**WEST SUSSEX COUNTY COUNCIL
PLANNING SERVICES CONSULTATION**

SUBJECT: FG/135/17/PL - Erection of 1 no. 2 bed dwelling.

South Point, Beehive Lane, Ferring, West Sussex, BN12 5NL

DRAWING TITLE
Apartment 9
Block and Location Plan

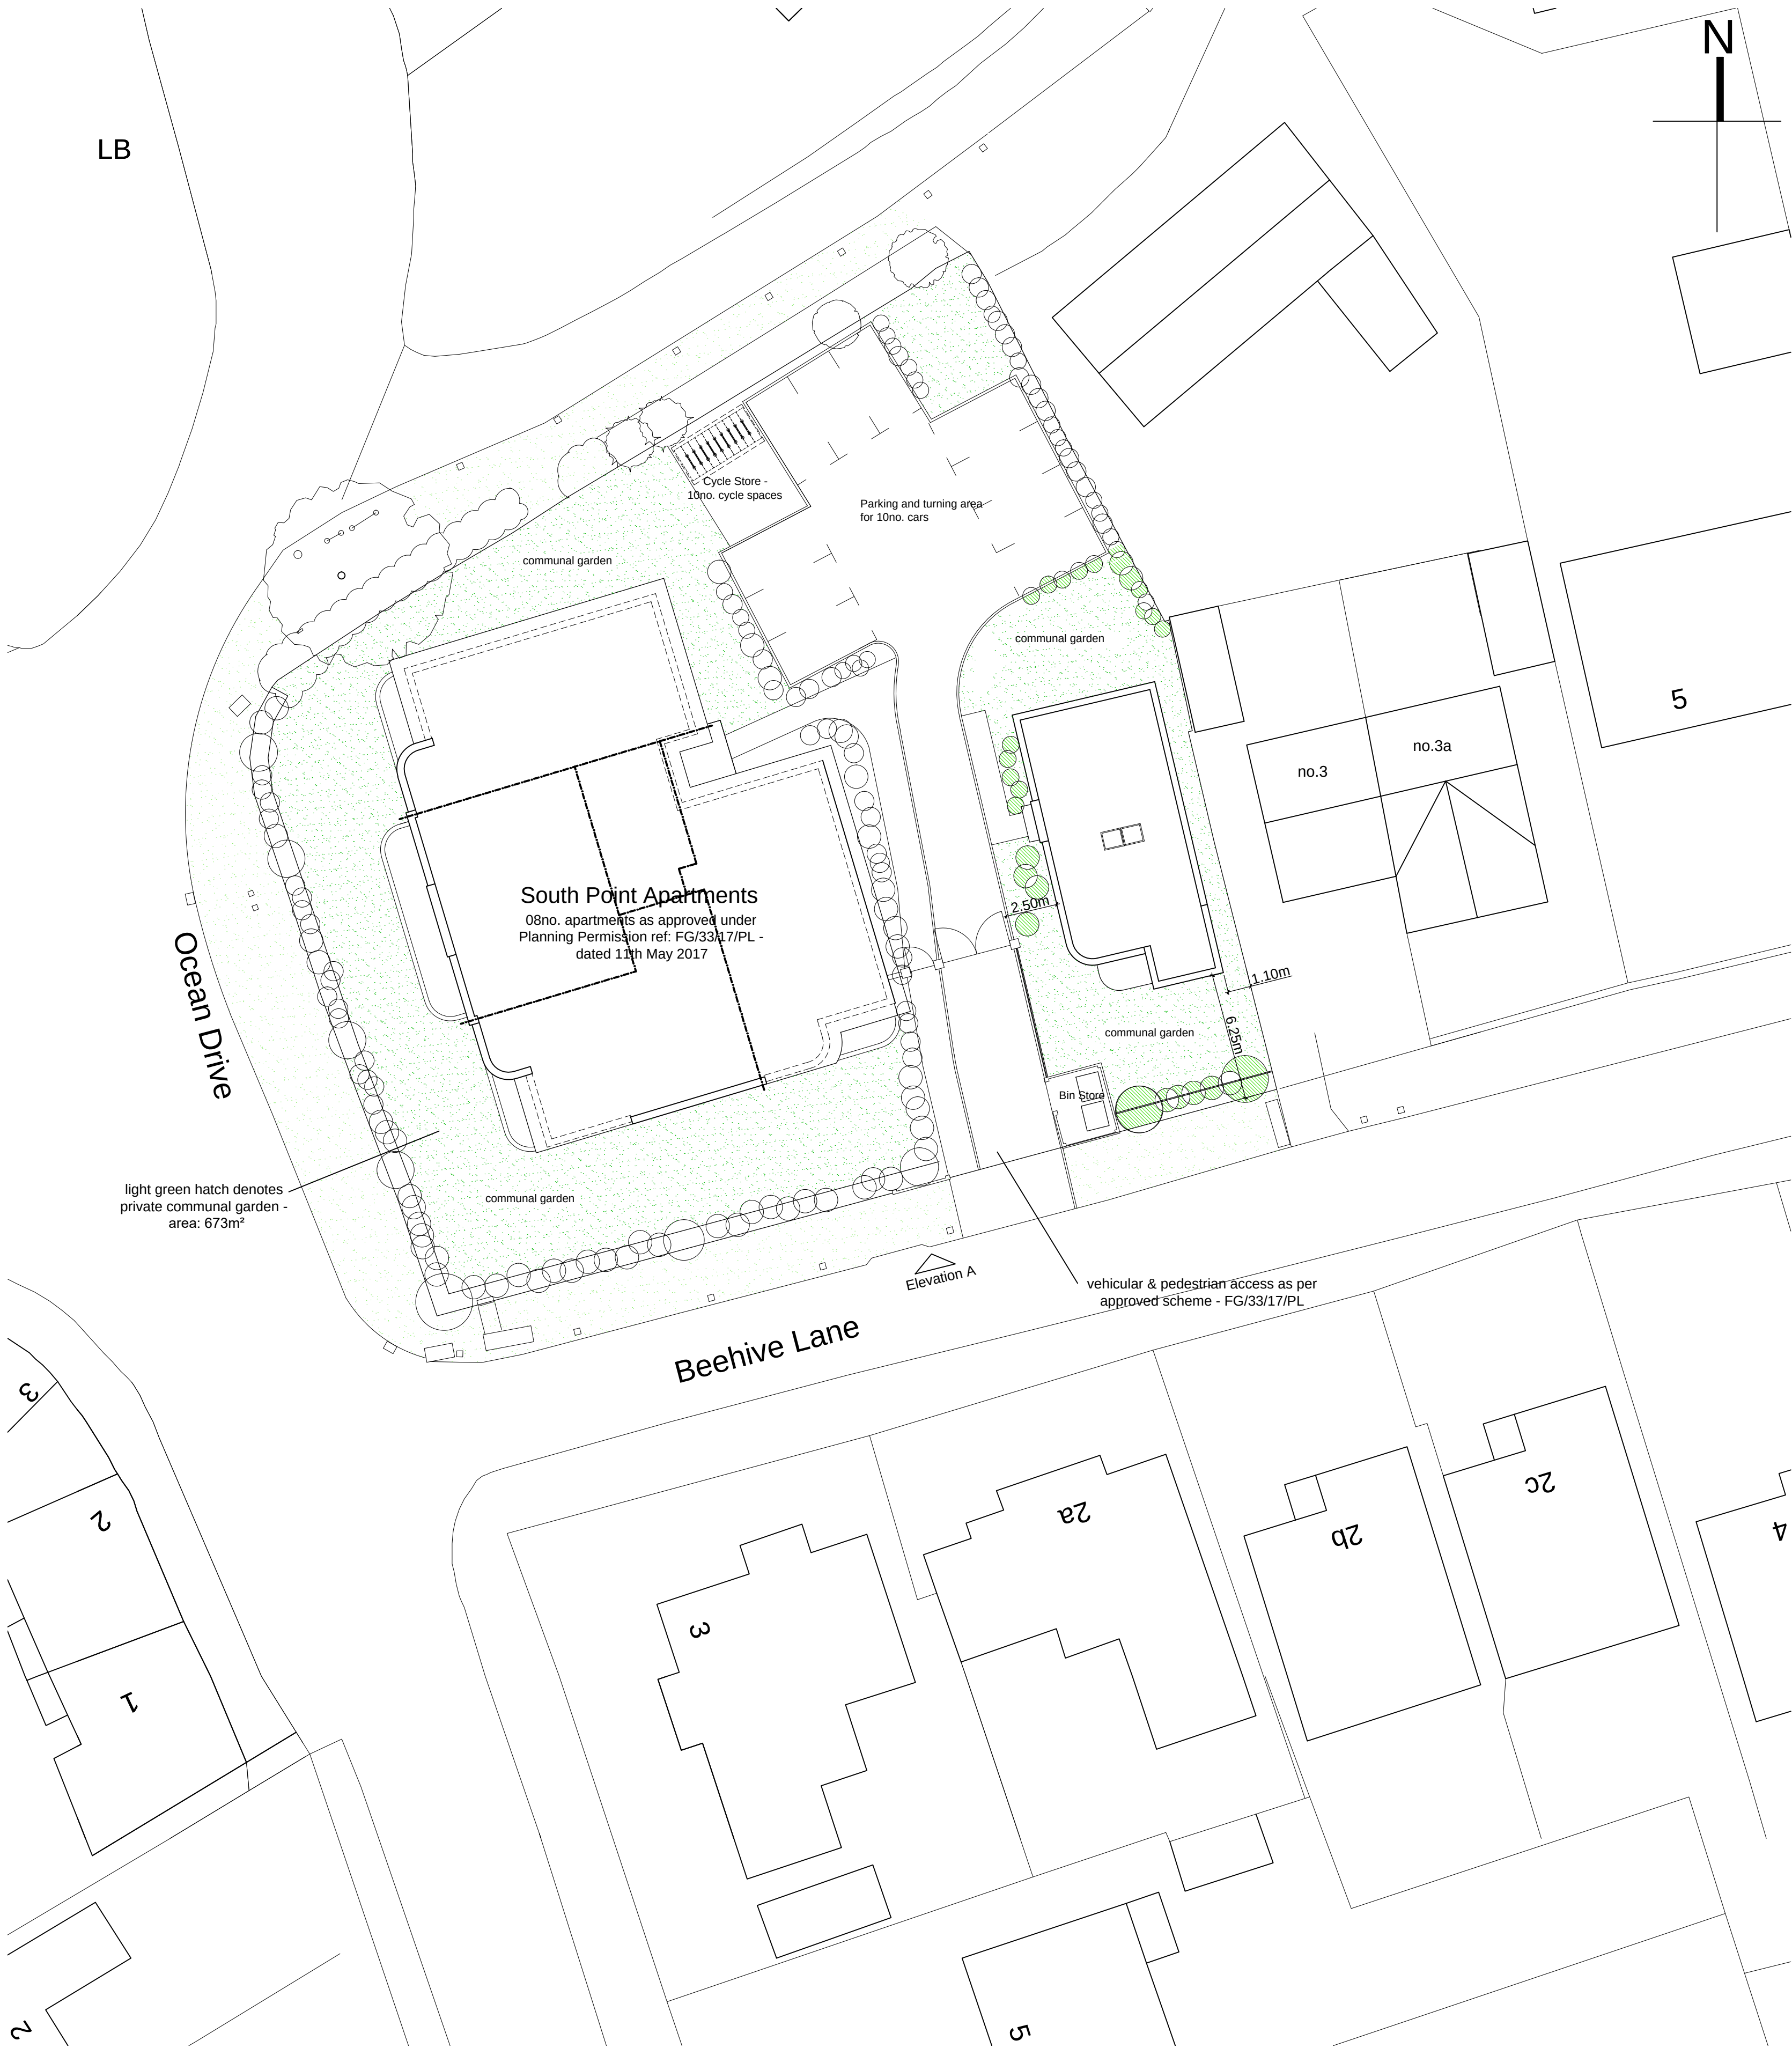
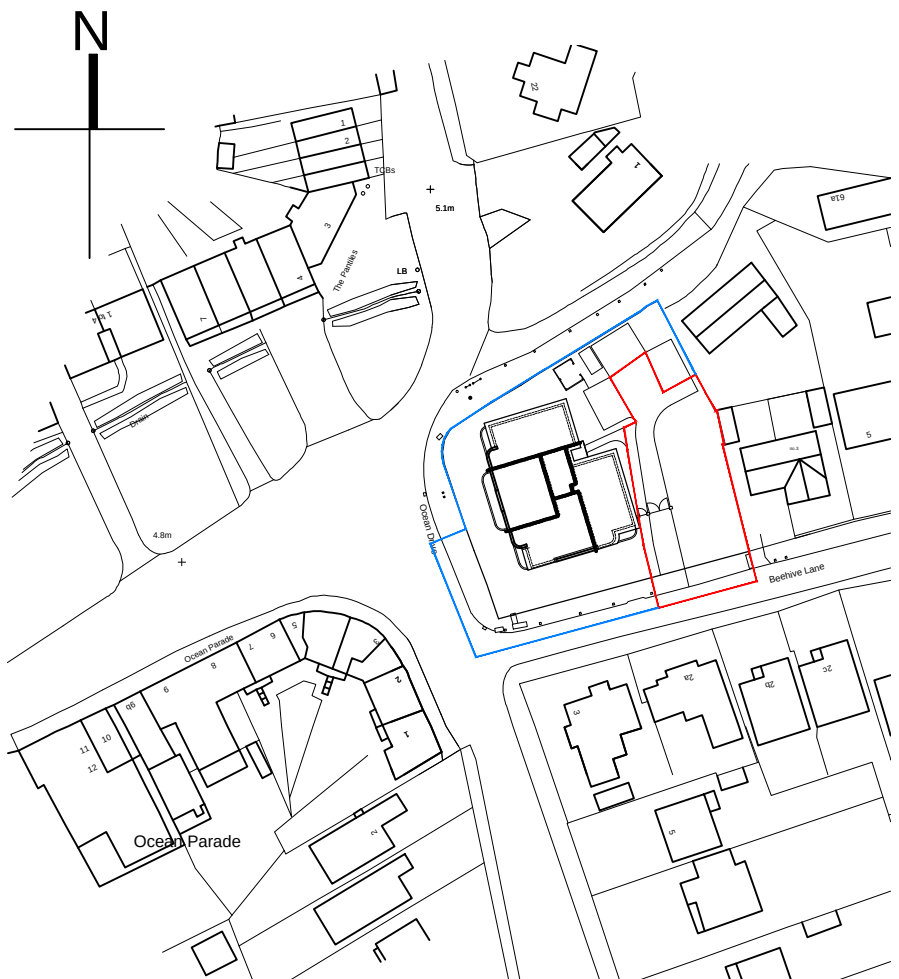
An inspection of the Design & Access Statement and block plan establishes that the new dwelling will utilise the access arrangements approved under FG/186/16/OUT & FG/33/17 for 8 x 2 bedroom apartments. The new dwelling will also have use of the shared cycle storage facilities and communal parking area consisting of 10 spaces. This meets with the WSCC Parking Demand Calculator.

In conclusion it is not anticipated that this proposal would be detrimental to highway safety, therefore, the LHA does not wish to raise any objections. If the LPA are minded to approve the application then the LHA would advise that a condition is applied to secure a Construction Management Plan that takes into consideration this additional dwelling on-site.

No development shall take place, including any works of demolition, until a Construction Management Plan has been submitted to and approved in writing by the Local Planning Authority. Thereafter the approved Plan shall be implemented and adhered to throughout the entire construction period. The Plan shall provide details as appropriate but not necessarily be restricted to the following matters,
